From: Laura Gibbons
Sent: 12 April 2019 15:58
To: Planning.Responses
Cc: David Easton
Subject: RE: Planning Consultation on BE/42/19/DOC

Engineers Comments Regarding Condition 25- surface water drainage

Description of Works: Approval of details reserved by condition imposed under ref
BE/61/13/ relating to Condition Nos 17-ecology, 24-flood
storage, 25-surface water drainage, 31-oil interceptor, 32- foul
water sewerage, 33-watercourses, 34- SUDs and 39-
Construction Management Plan.

Project No:	Scale (@A1):	Drawn:	Date:
1620003993	1:10	CL	JUN.19
Drawing No:	Rev:		
RAM-0500-1A-DR-CR-10003	P01

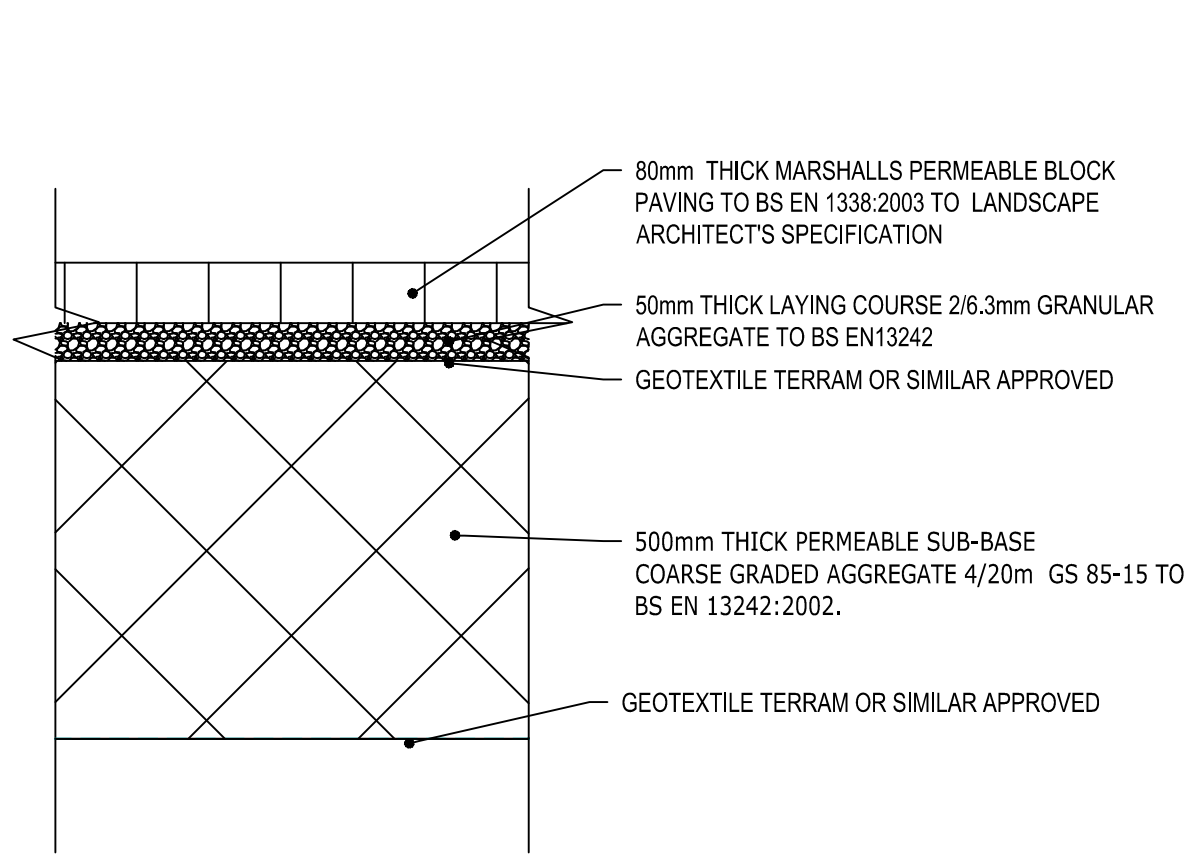
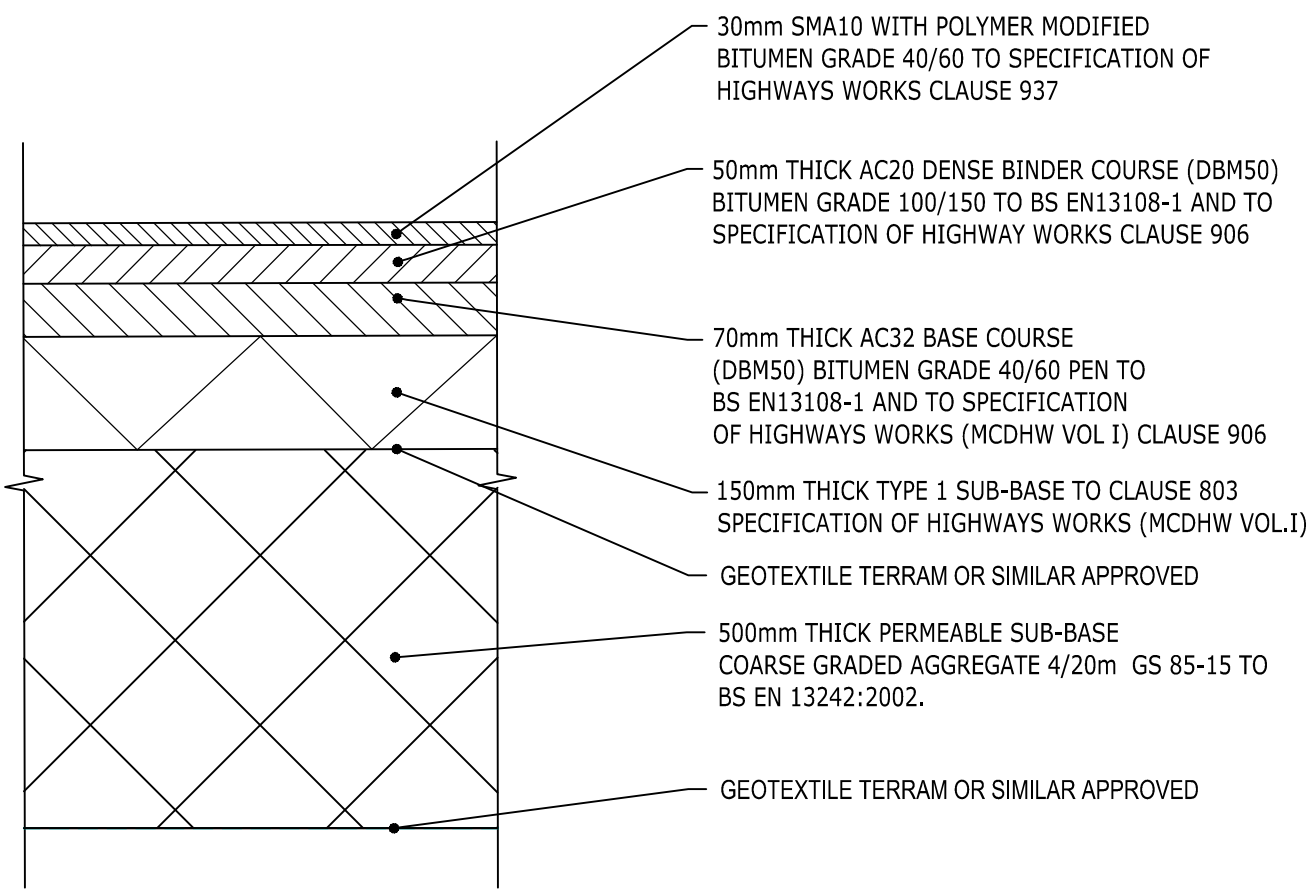
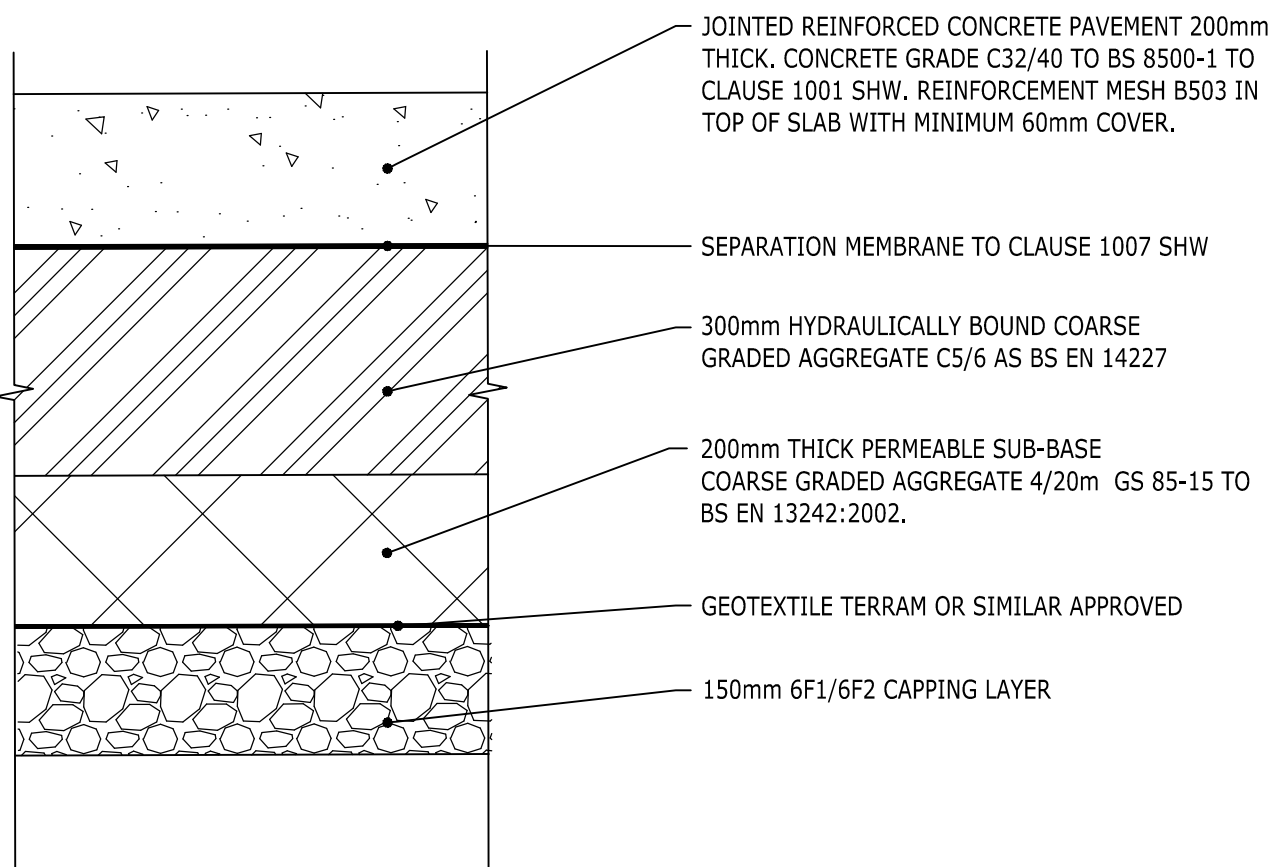
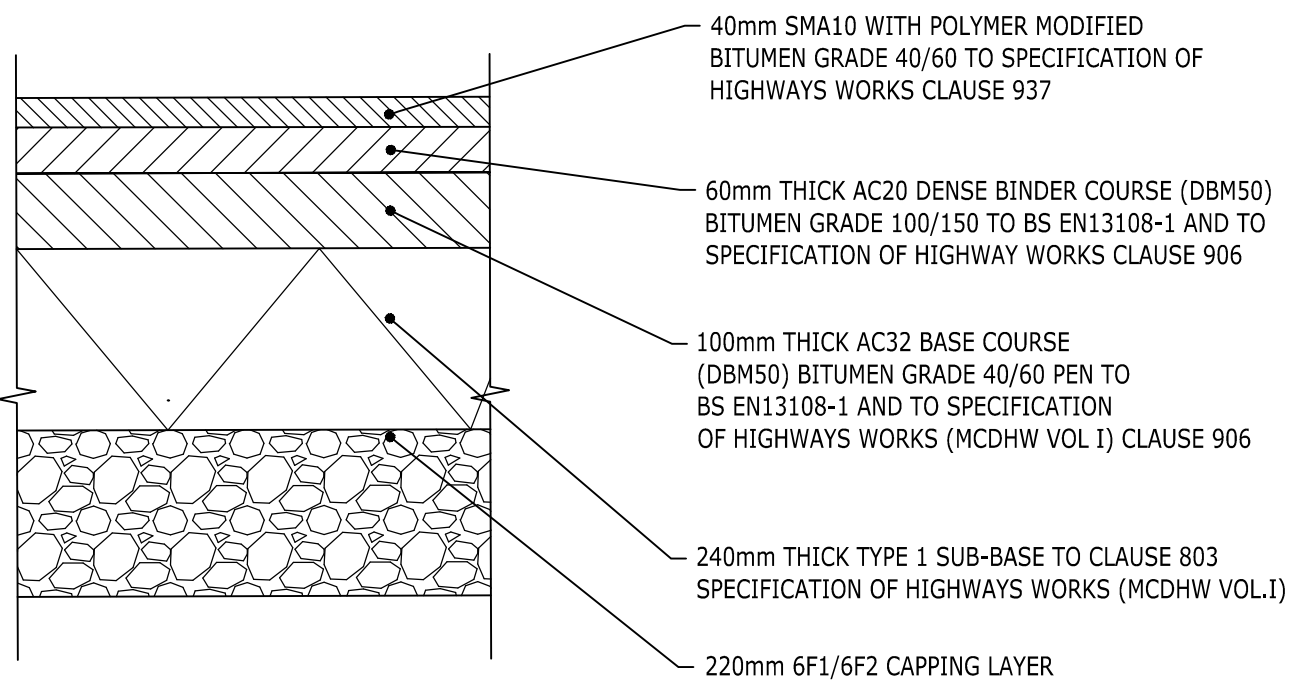
10. Please provide construction detail drawings of permeable paving. Only impermeable block paving details have been provided.
 11. The construction details provided for impermeable block paving show an impermeable liner around the diffuser unit. Please correct this.

12. The calculations for permeable paving state that a flat sub base is to be constructed, yet the strategy for surface water drainage and the construction details which have been provided both suggest that a sloping sub base is required and specified. Please ensure that details are consistent.
